Application No: FG/155/25/PL

Site Address: Land between 11A The Grove and 30 Brook Lane Ferring BN12 5HZ

Description of works: Erection of 1 No 1-bedroom self build house with associated parking & private outdoor amenity space. This application is in CIL Zone 4 and is CIL Liable as a new dwelling.

Thank you for your internet representation made on 25th January 2026 which has been recorded as an objection with the comments as follows:

A :: Block Plan
01 scale: 1:200

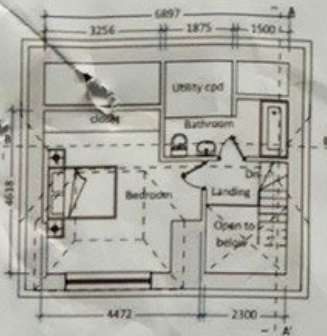
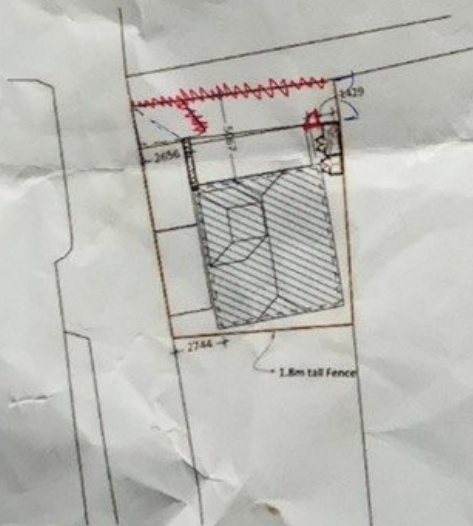
The back garden fence and gates restricts our ability to park off road ,and therefore would have to park our two vehicles on road .The grove has limited on road parking,
